Together Against Sizewell C

APPLICATION BY NNB GENERATION COMPANY (SZC) LIMITED
FOR A DCO GRANTING CONSENT FOR THE SIZEWELL C PROJECT

DEADLINE 6 SUBMISSION

COMMENTS RELATING TO THE APPLICANT'S D5 SUBMISSIONS REP5-111 & REP5 118

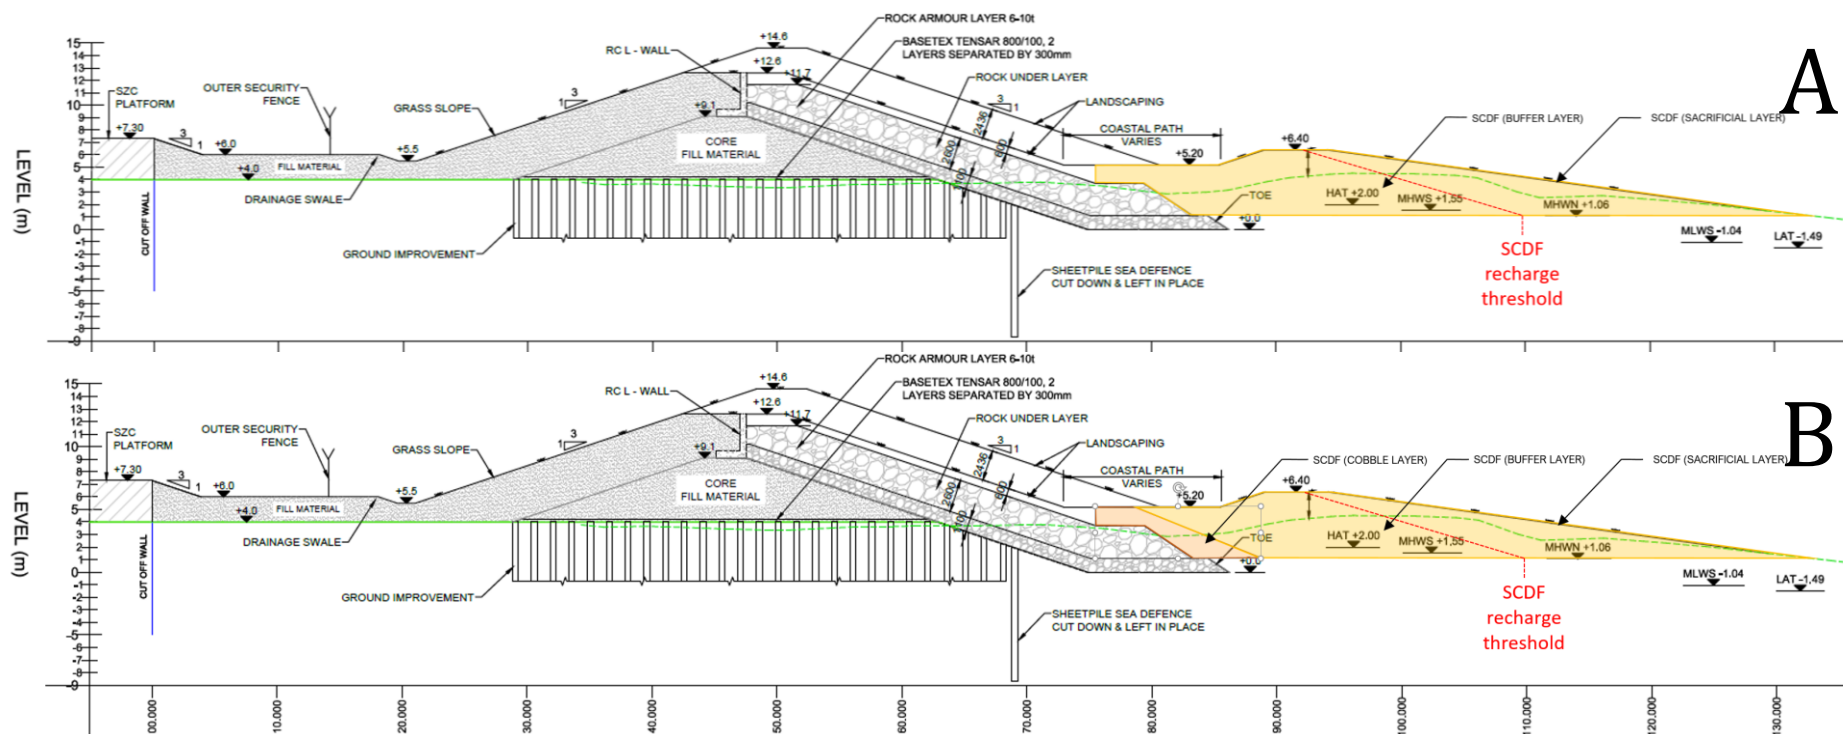
4. **Para 1.11.3** refers to "the natural function of the geomorphic system over the operations and decommissioning phases". TASC cannot see how this statement is justified when the Applicant is proposing to introduce thousands (perhaps millions?) of tonnes of aggregates, including those not 'naturally' found on the Sizewell shore through replenishment of the SCDF.

DRAWING TITLE:
PERMANENT COASTAL DEFENCE FEATURE
TYPICAL SECTIONS (MAIN)

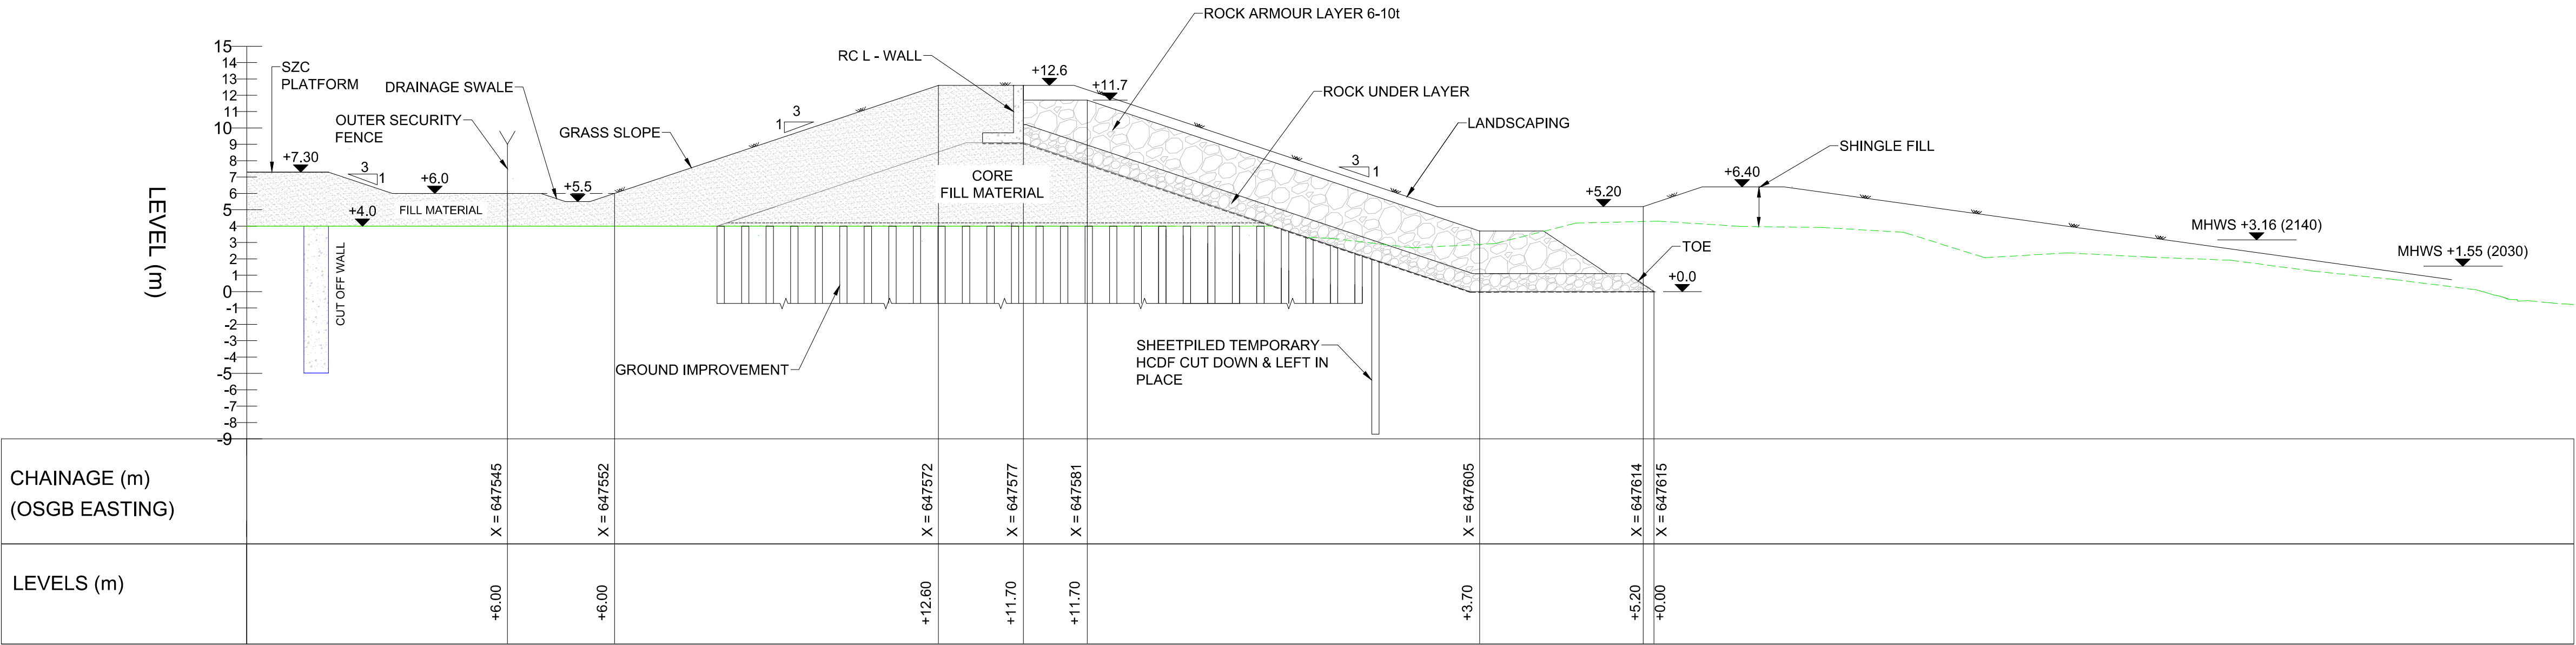
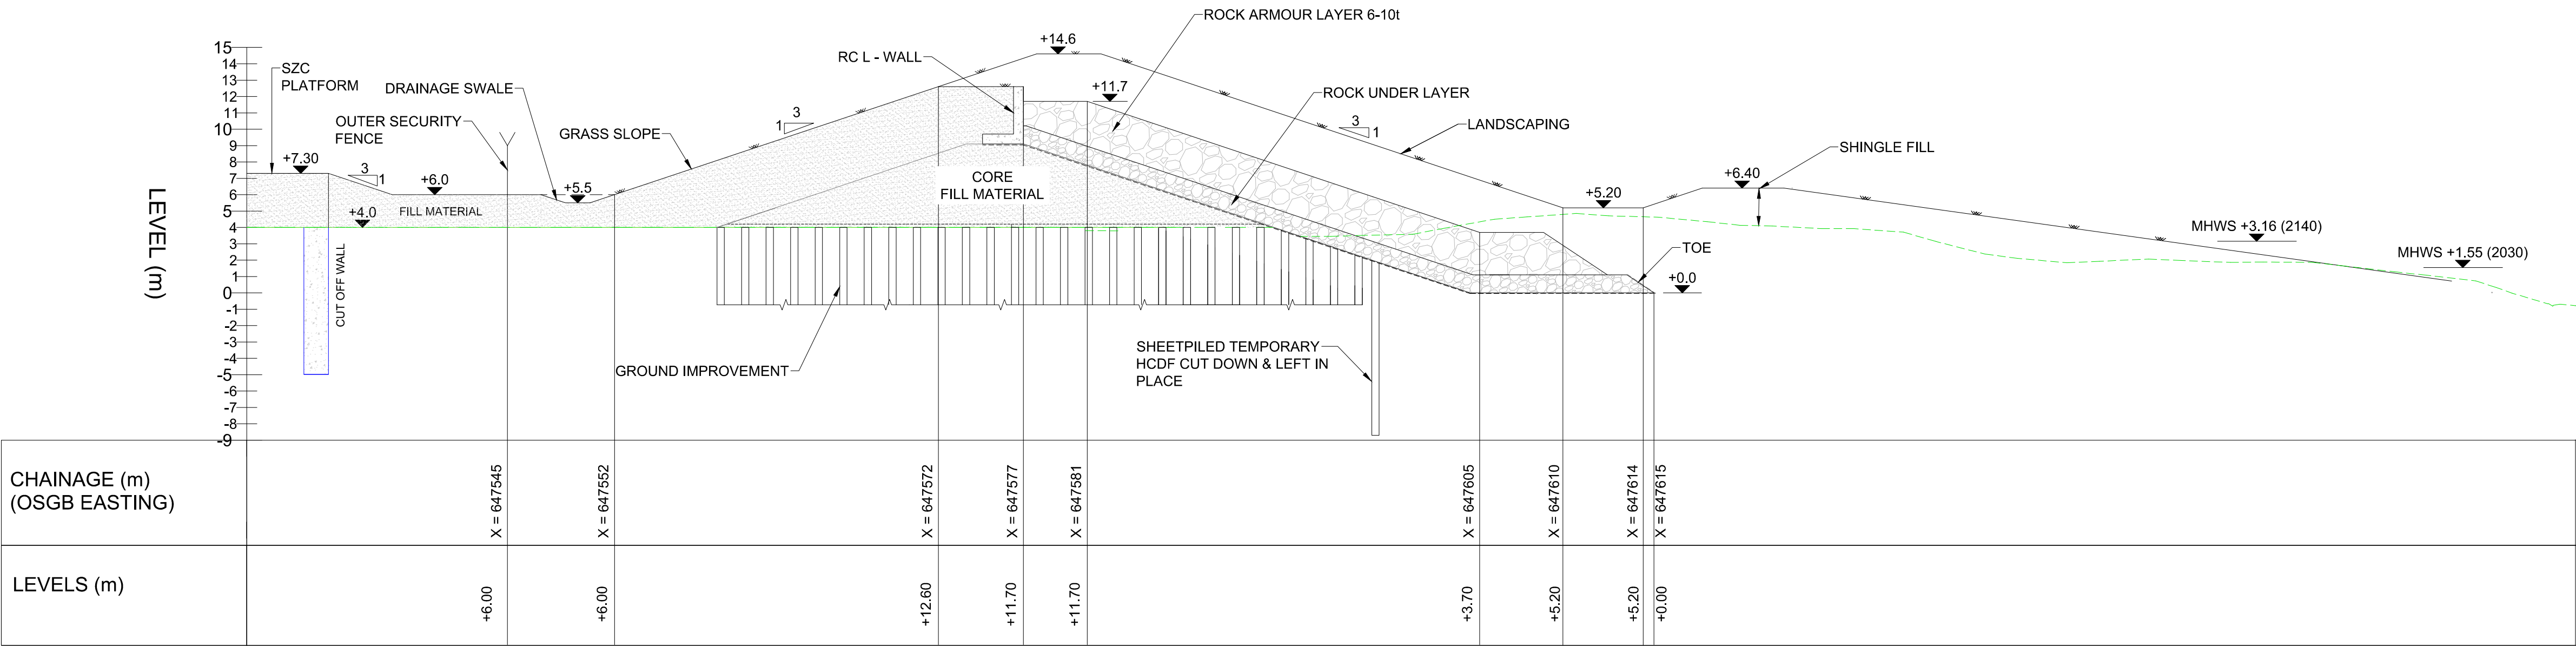
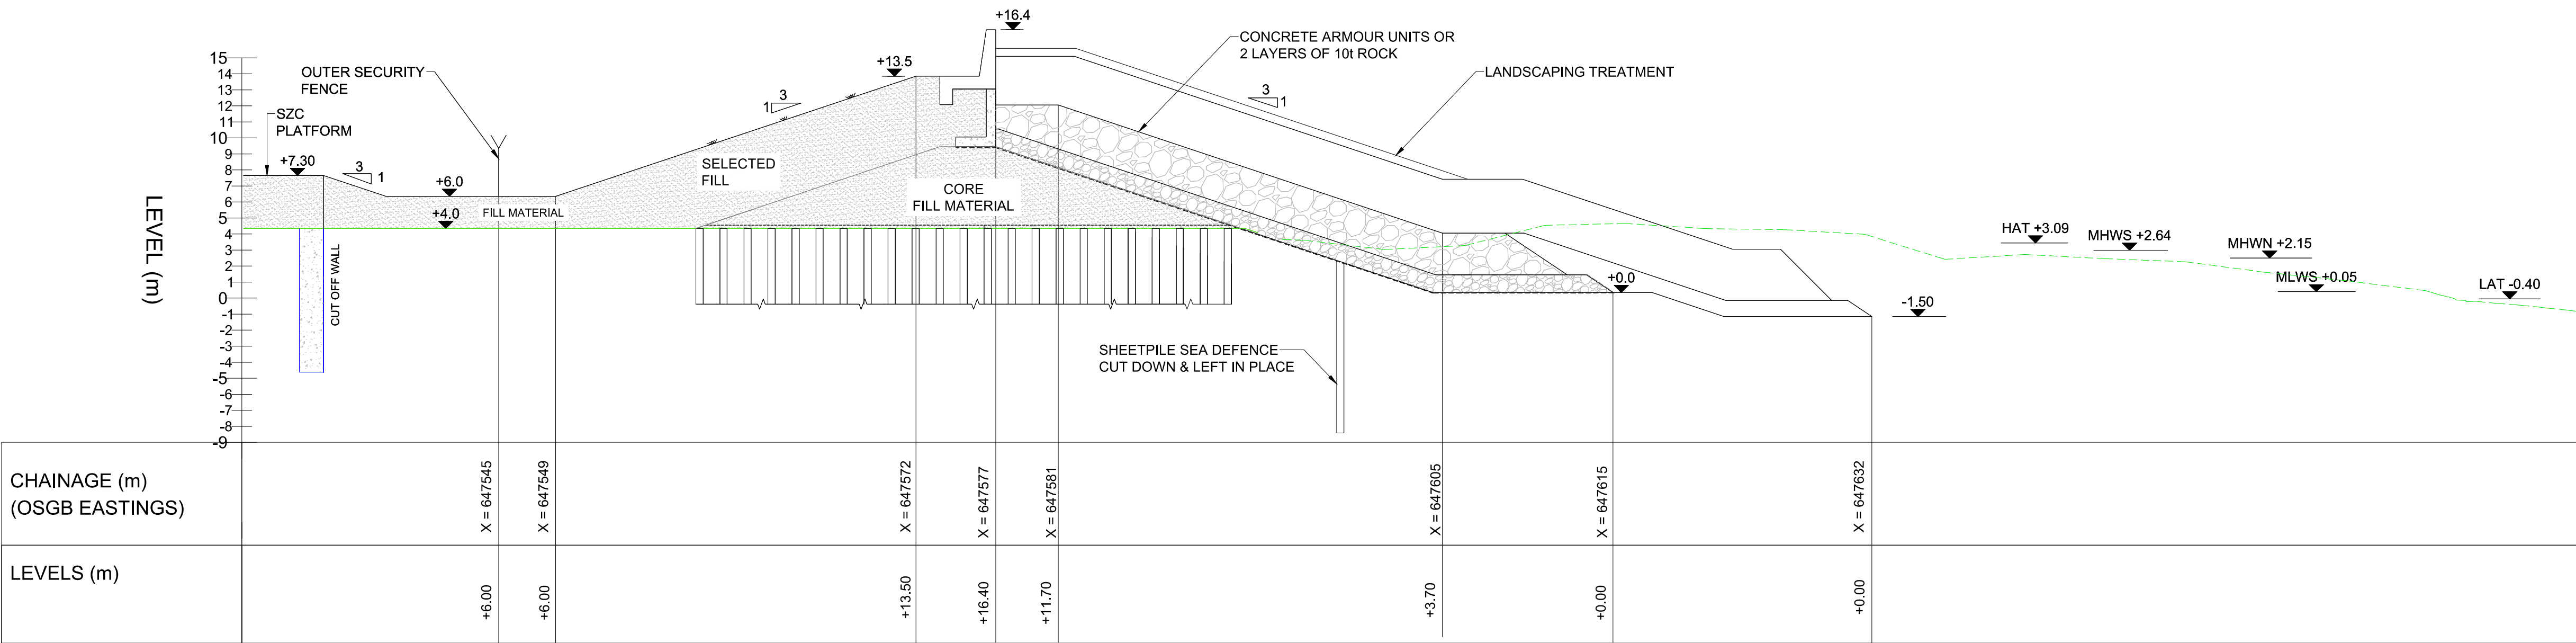
3. **Para 1.10.1** refers to the diagrams of the sea defences mentioned in Appendix A of document 9.53. In TASC's opinion, the diagrams are extremely poor, being hard to decipher as you cannot tell which line is which, even when using a magnifying glass! Absolutely useless as almost impossible to ascertain any detail.

5. **Para 1.11.6** states that the coastal defences are viable up to 2099 but how can a potentially compromised design, which has not been adequately assessed, be considered appropriate? It seems from other IPs, including representations from Bill Parker [REP5-191], Nick Scarr [REP5-129] and the Alde and Ore Association [REP5—187], that the Applicant's modelling falls short by under-assessing the risk of erosion and therefore flood-risk. Having ignored the distinct possibility of the loss of the Dunwich Bank, by ignoring historic coastal changes in the region, by failing to assess wave impacts correctly, the Applicant cannot be certain that the Sizewell Coast will not revert to its historic state of extensive erosion.
